From: Sarah Burrow <Sarah.Burrow@arun.gov.uk>
Sent: 05 May 2021 13:35
To: Planning.Responses <Planning.Responses@arun.gov.uk>
Cc: Simon Davis <Simon.Davis@arun.gov.uk>; Paul Cann <Paul.Cann@arun.gov.uk>
Subject: RE: Planning Consultation on: P/38/21/PL

Engineers Comments Regarding Surface Water Drainage

Application No: P/38/21/PL

Site Address: Little Sefter Farm Pagham Road Pagham

PROJECT	BARN EXTENSION BARFOOTS - LITTLE SEFTER PAGHAM RD, BOGNOR REGIS WEST SUSSEX, PO20 1LN				
DRAWING	DRAFT PROPOSED EXTERNAL LEVELS & CONSTRUCTION FINISHES				
SCALE	PTN No	FC2846/03	REV	B	
Varies	DATE	JAN 20	INITIAL	MH	CHKD

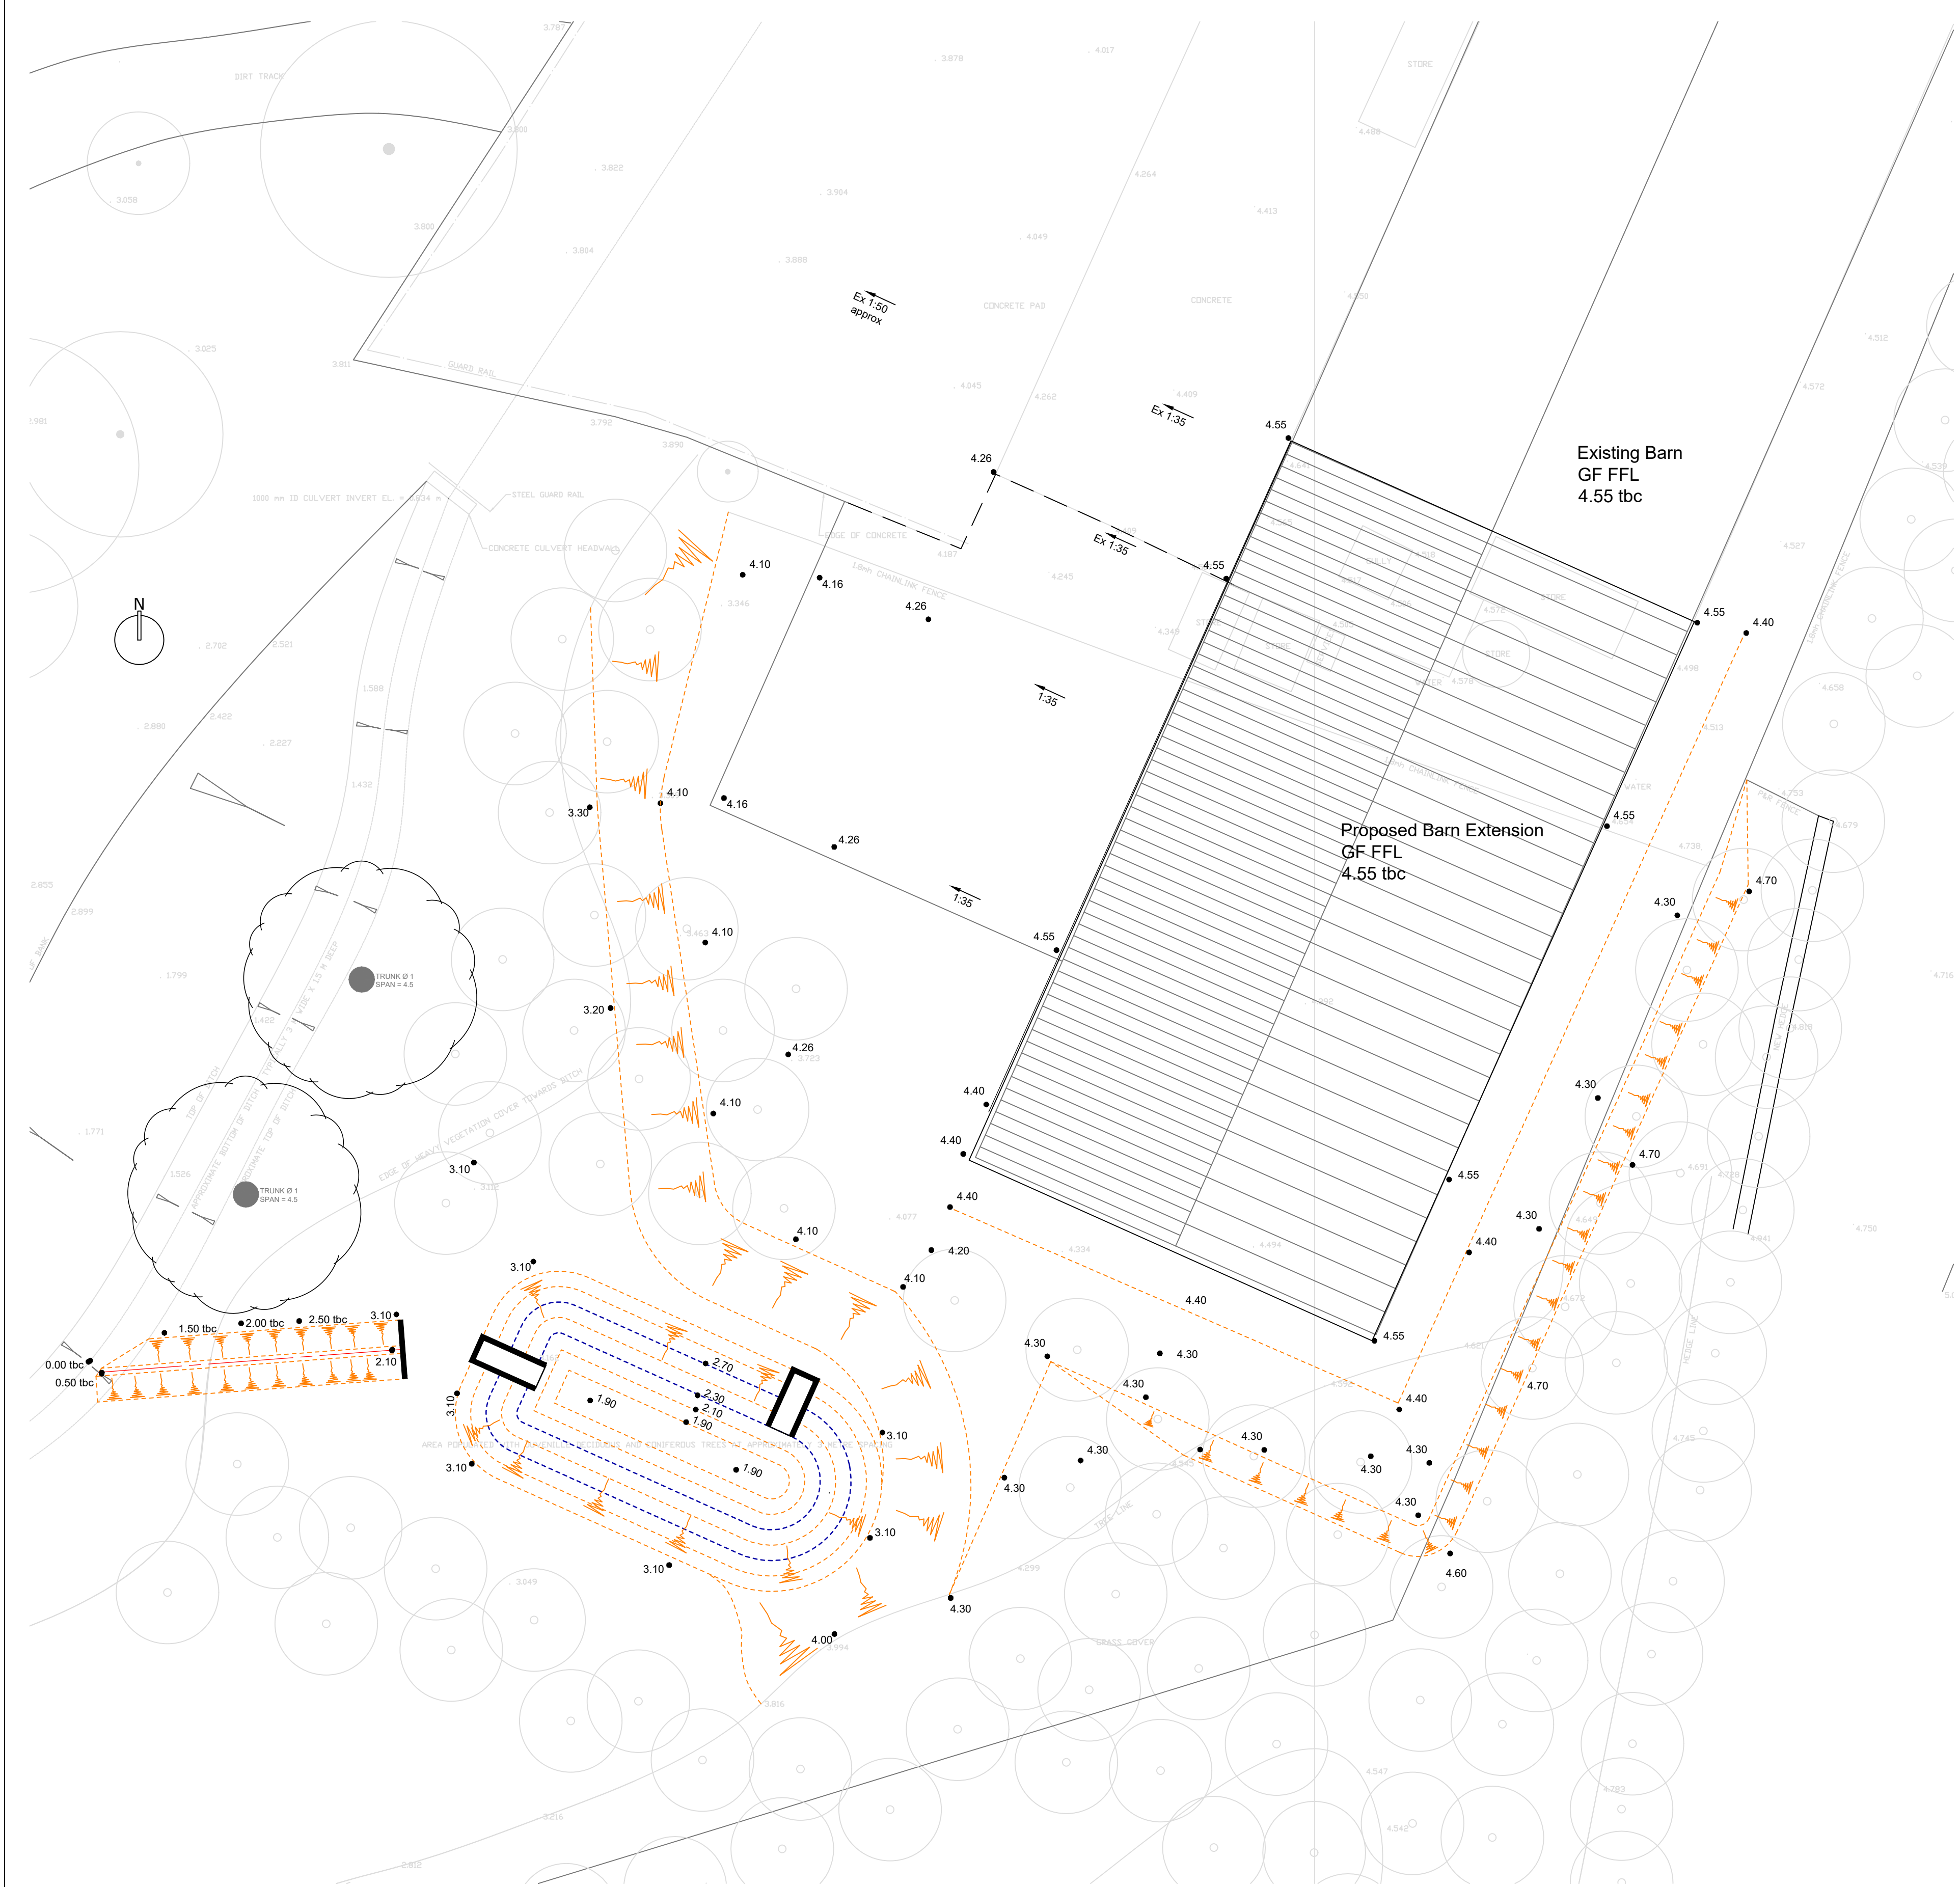
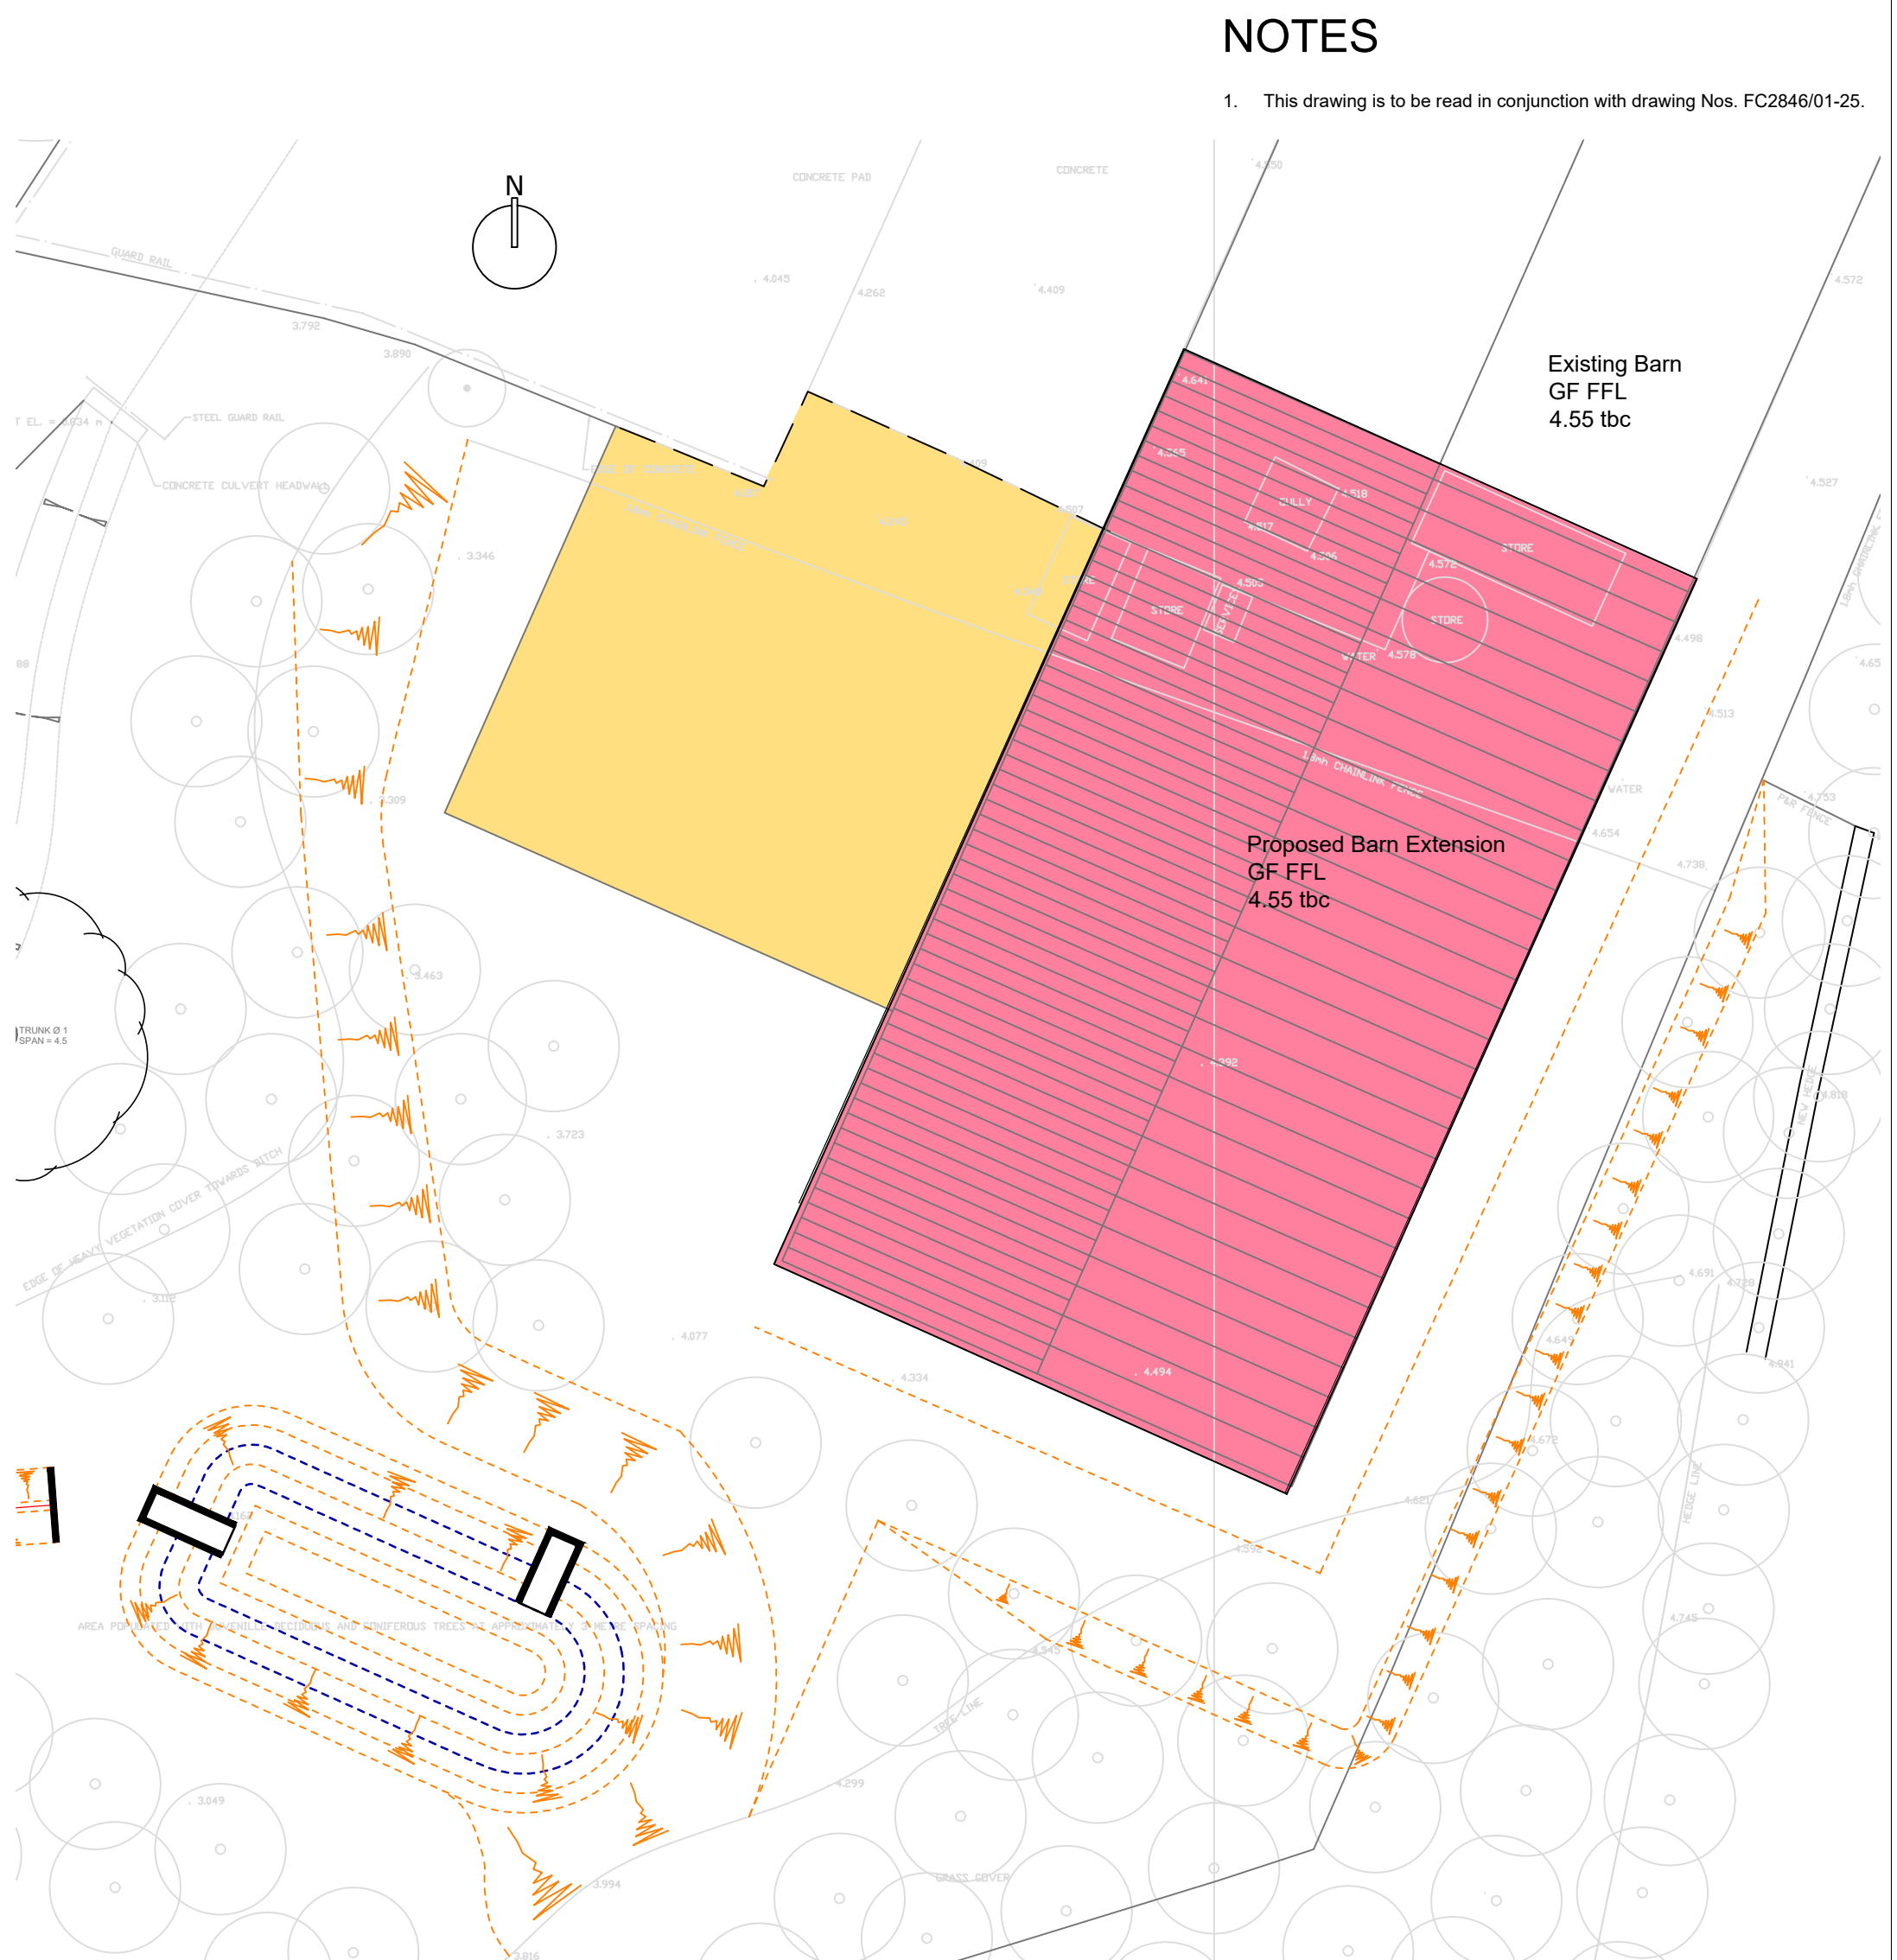
The applicant has considered and incorporated a surface water drainage strategy into the design and application. Infiltration testing has shown that infiltration is not a viable method for draining surface water on the site, therefore the applicant is proposing that surface water is drained to a balancing pond before discharging at a restricted rate to the watercourse on site. The proposed strategy is acceptable however there are details which require amendment, these will affect the calculations and the Drainage Layout, most importantly increasing the capacity of the pond and changing the hydrobrake.

The applicant has proposed a restricted run off rate post-development of 5l/s. This is significantly higher than the greenfield runoff rate and will not be acceptable for an approved design. It is expected that the runoff rate is reduced to 2l/s with features to reduce risk of blockage incorporated into the design.
